April 6, 2020

Harnett County Government Complex
307 W. Cornelius Harnett Boulevard
Lillington, NC 27546

El Burrito Mexican Restaurant

We are unable to begin your plan review because your application is incomplete. Please resubmit your application to us with all requested information included.

7 DUMPSTER PAD

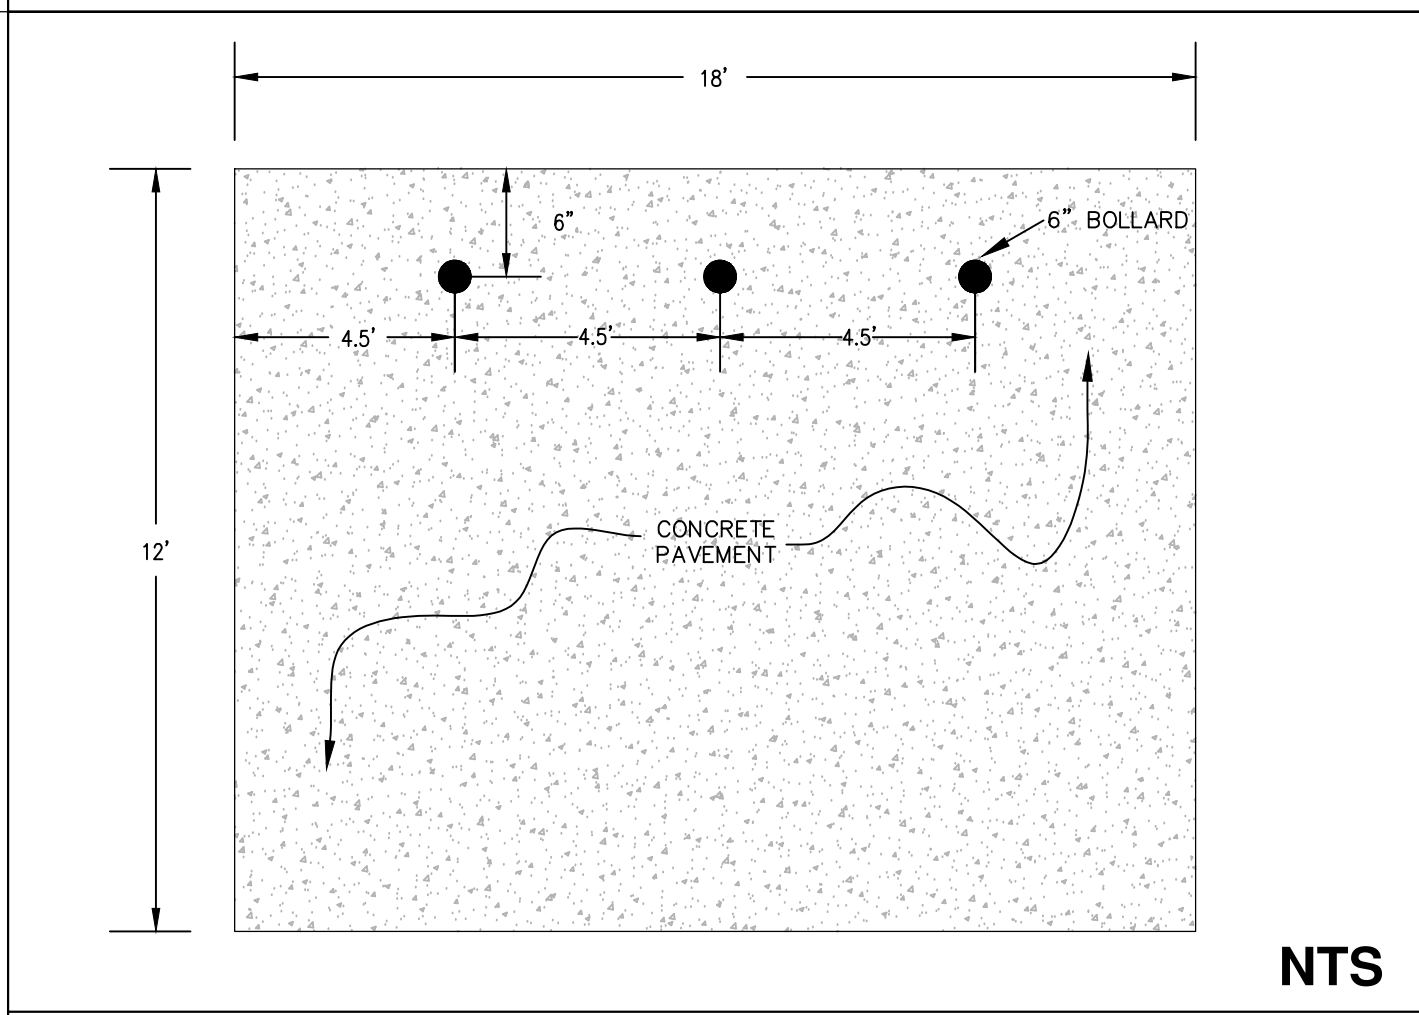
3. Indicate location of dumpsters.
4. What, if any, equipment will be existing from previous establishment?
5. You indicated you would be using time for public health control (TPHC) on your application but did not go into further detail.
